KITTITAS COUNTY

MEMORANDUM

TO: All Staff
FROM: Public Works Plan Review Team
DATE: October 6, 2025
SUBJECT: BL-25-00014 Voshall

RECORD OF SURVEY PART OF THE SECTIONS 22 & 23, TOWNSHIP 18 NORTH, RANGE 18 EAST, W.M.

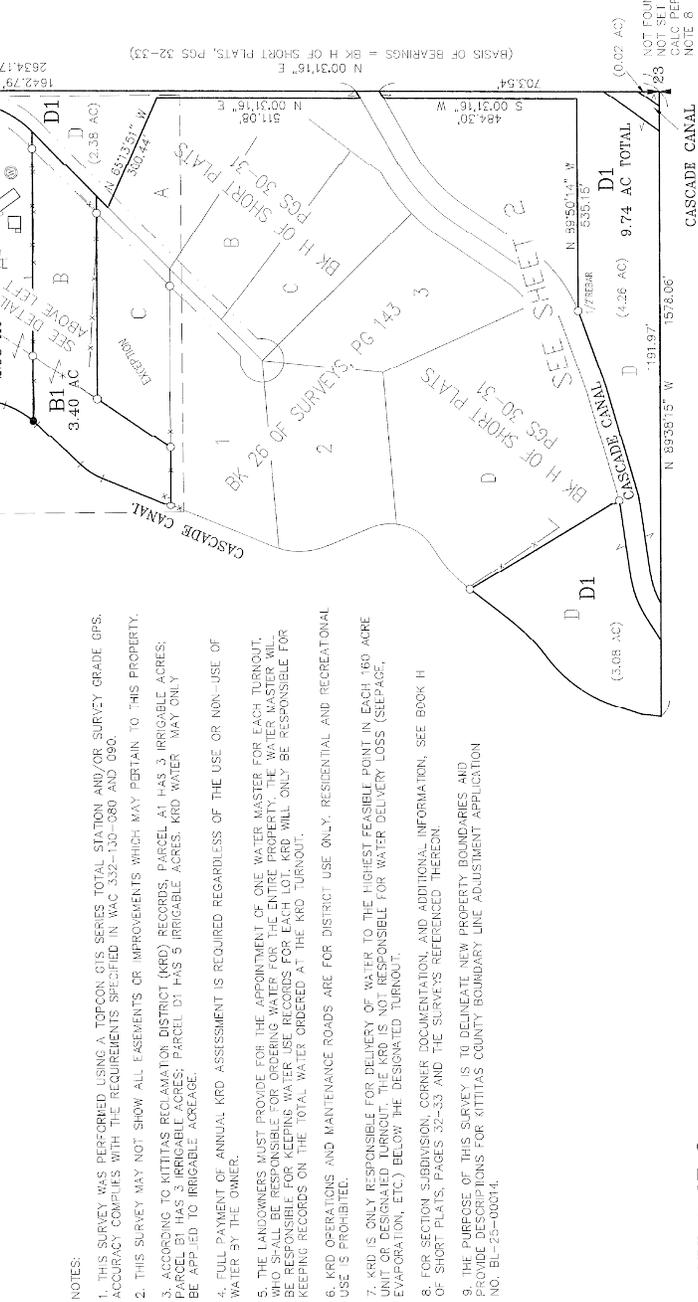
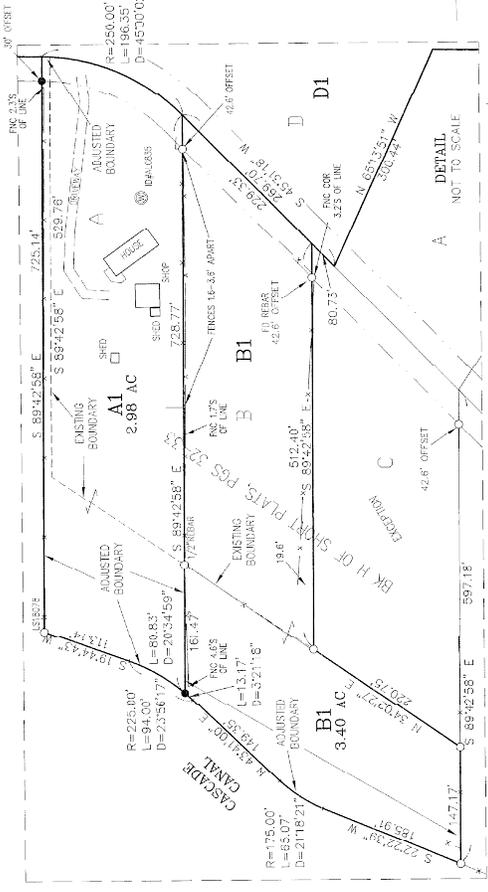
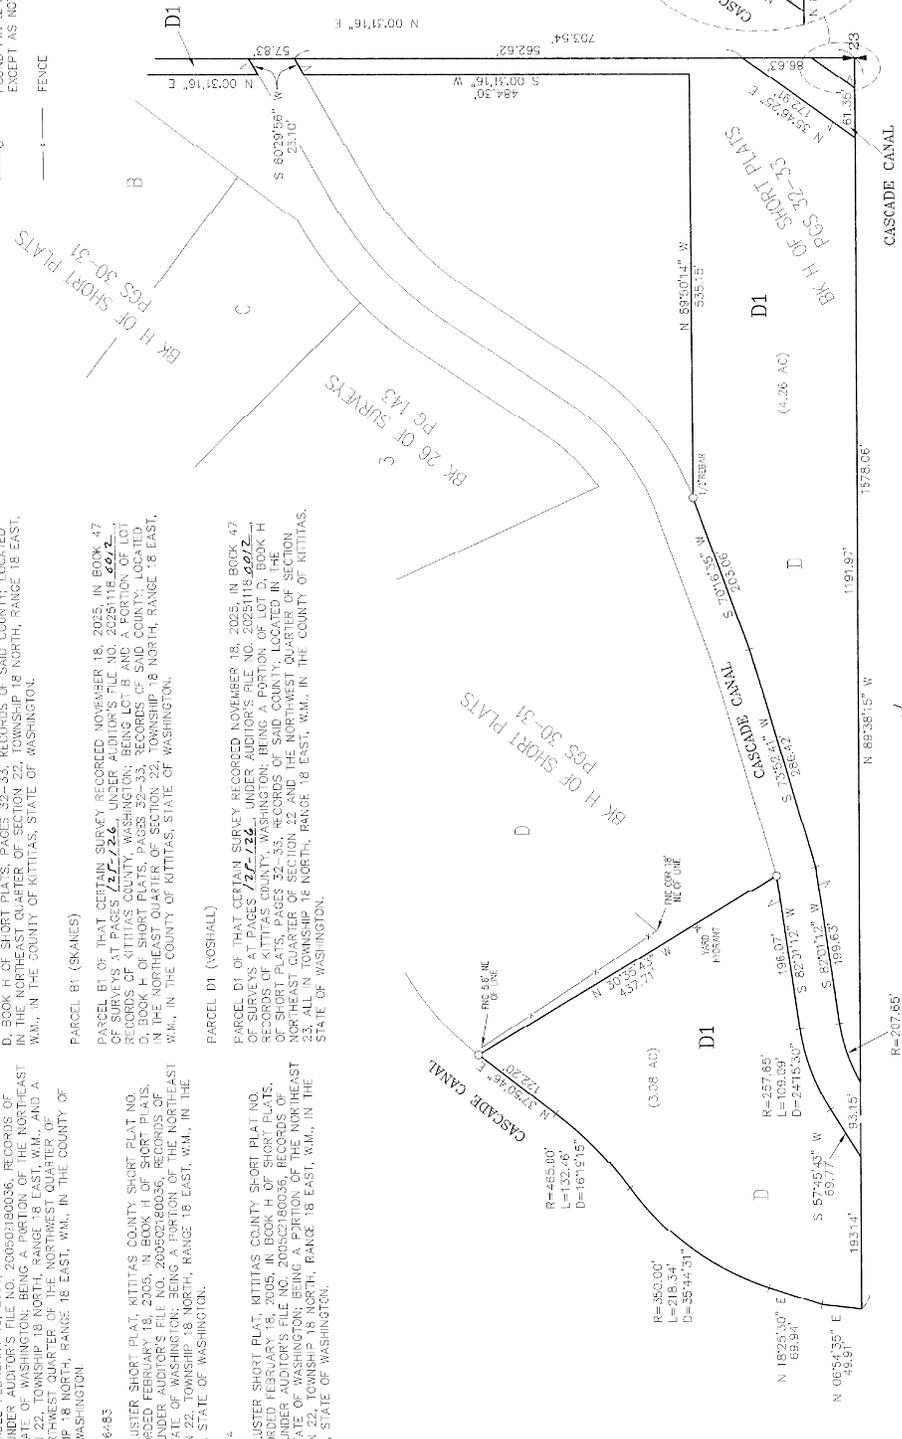
SURVEY	As the application does not contain a survey map, comments are reserved until final submittal. (JT)
TRANSPORTATION CONCURRENCY	No transportation concurrency management requirement for this project. (KAH)
FLOOD	The proposed project is not within a FEMA identified special flood hazard area (100-year floodplain). A floodplain development permit is not required. (RC)
WATER MITIGATION/ METERING	No Comment. (RC)
AIRPORT	No Comments. (RC)
